RE: Application 3/2025/0588 Full Planning Application for the Erection of 77.no Affordable Dwellings with Associated Access, Gardens, Parking and Landscaping areas.

This letter represents a formal objection to the above application on behalf of [REDACTED]. The letter supplements a letter which has already been submitted by [REDACTED] on the 25th August.

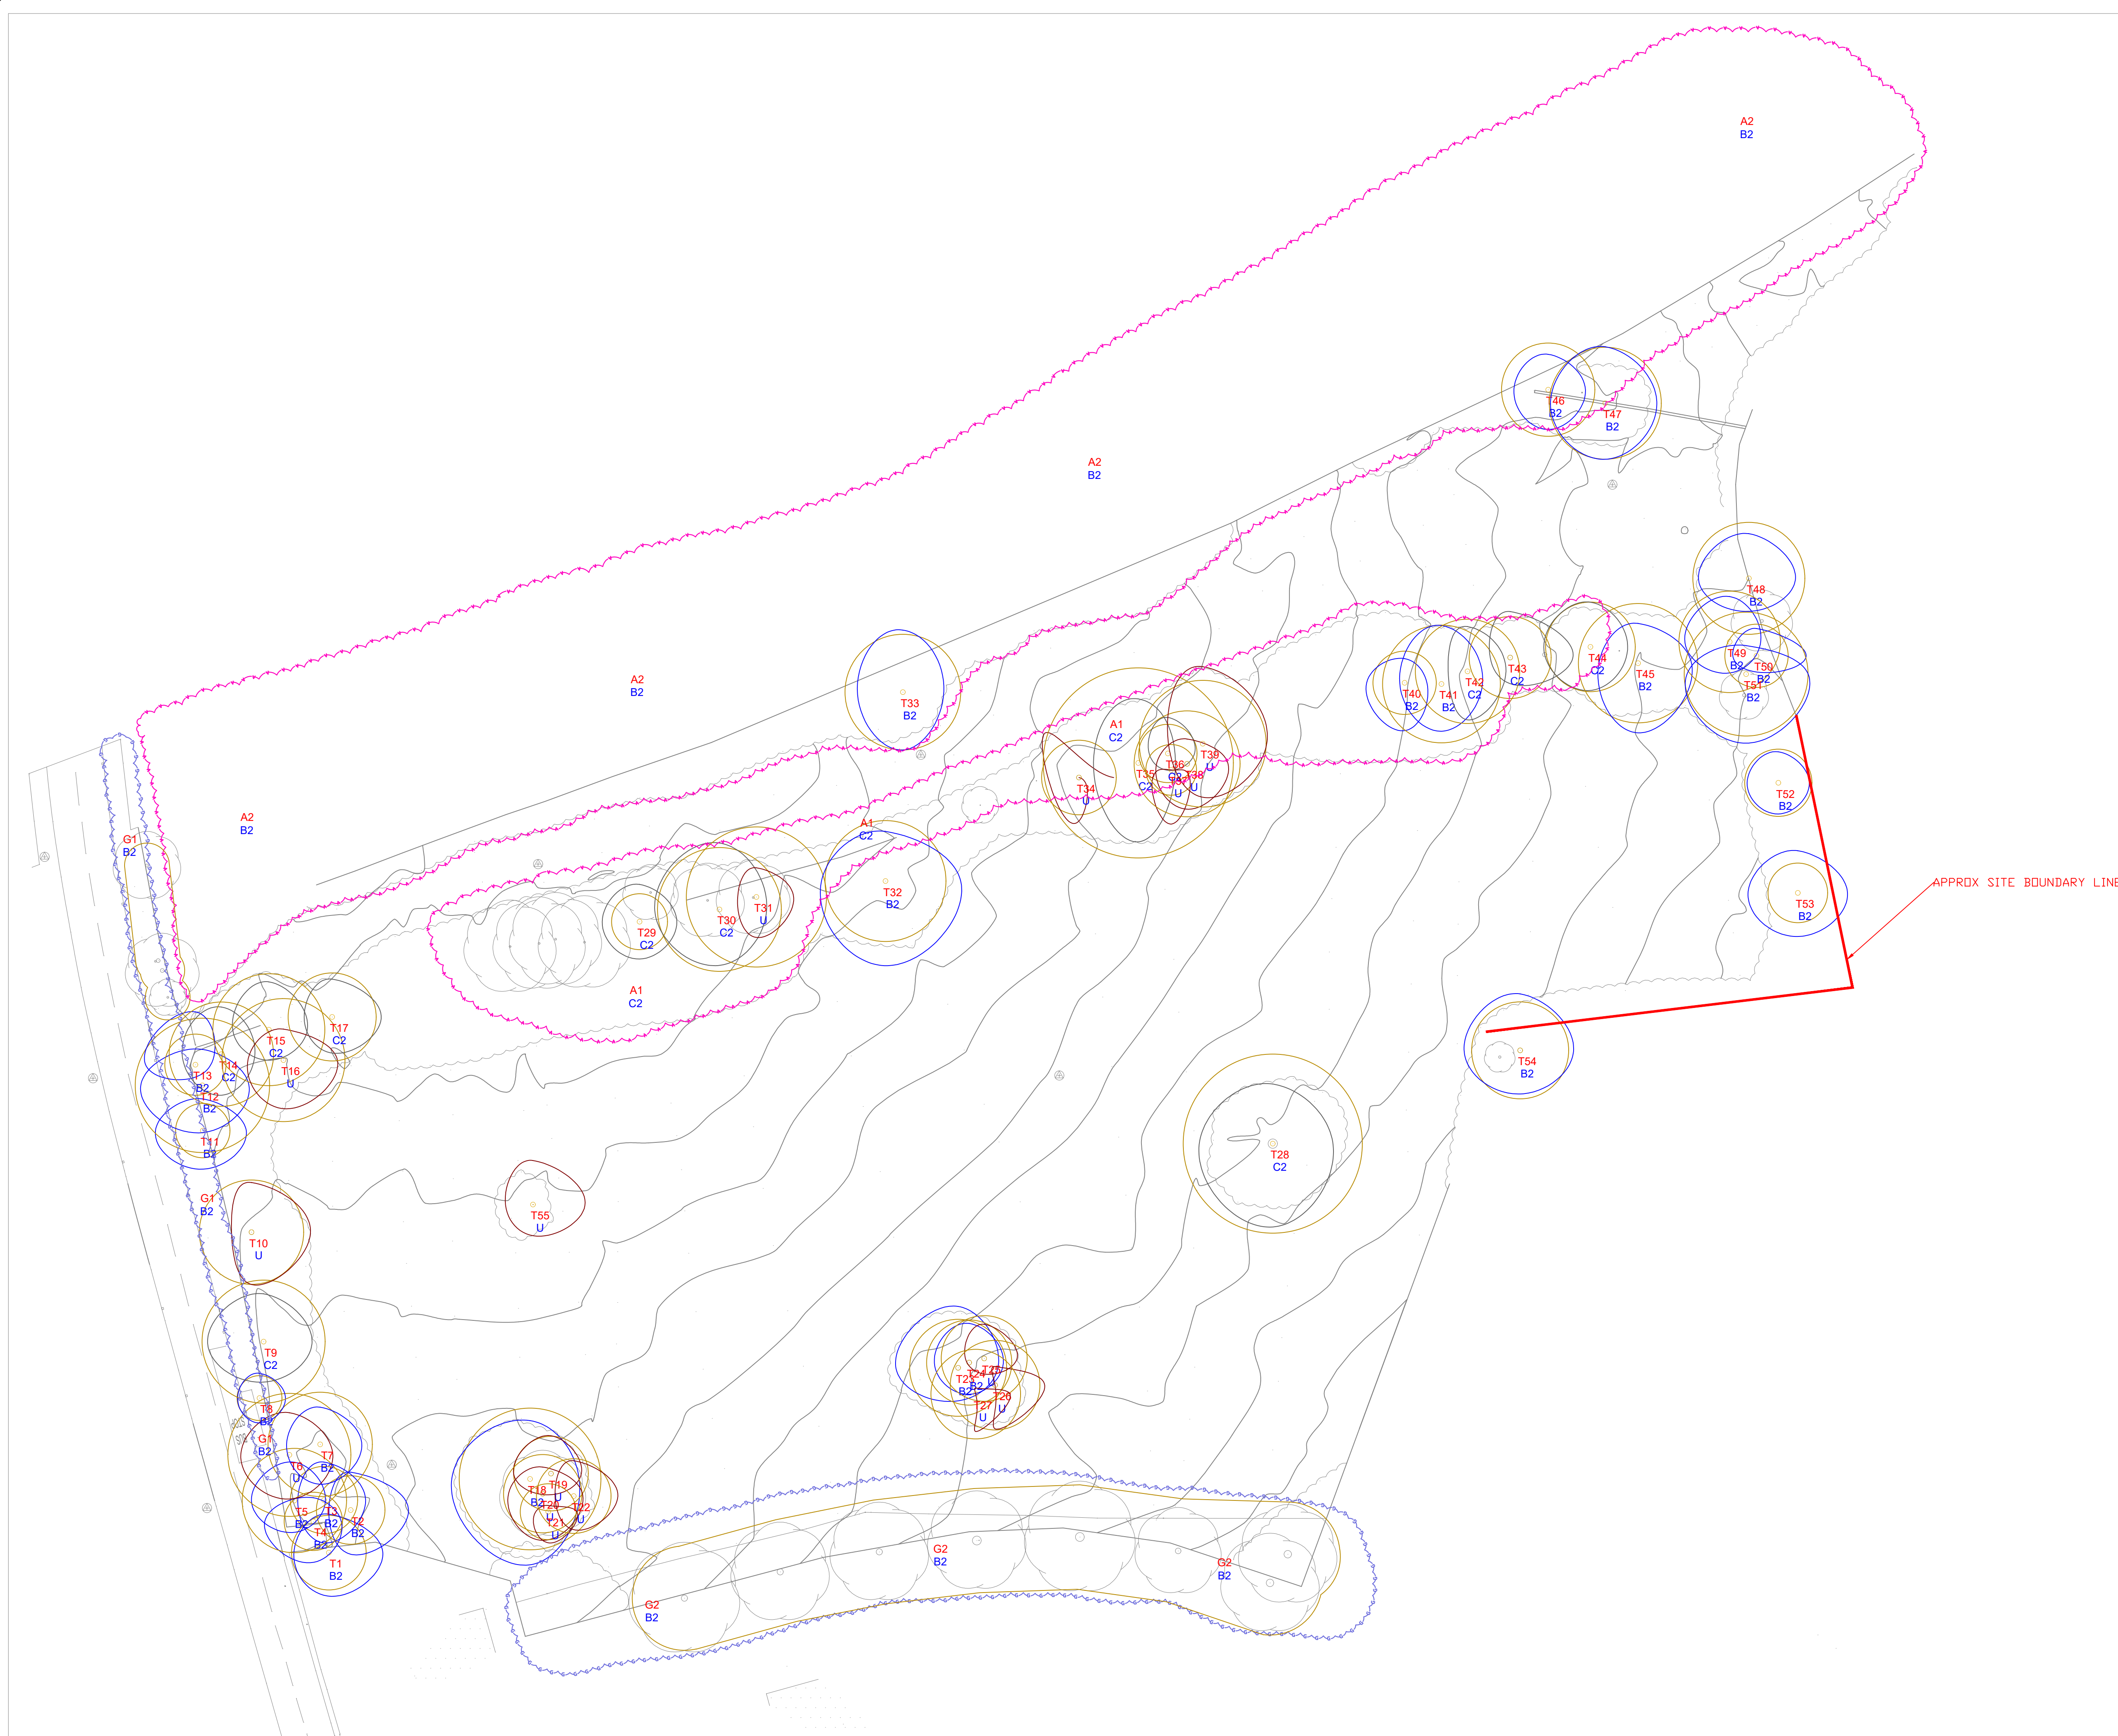
Whilst the application has been supported with the necessary Tree Reports, no consideration has been taken to the trees which lie on the [REDACTED]. Many of these trees are covered by TPO and make a positive contribution to the character of the area and support biodiversity.

There are huge concerns that the RPA of some of the trees will be compromised especially along the southern and eastern boundaries, where some of the proposed housing is shown to be right up to the fence line. It is considered that the proposed development will not comply with Policy DME1 (Protecting Trees and Woodlands), which amongst other
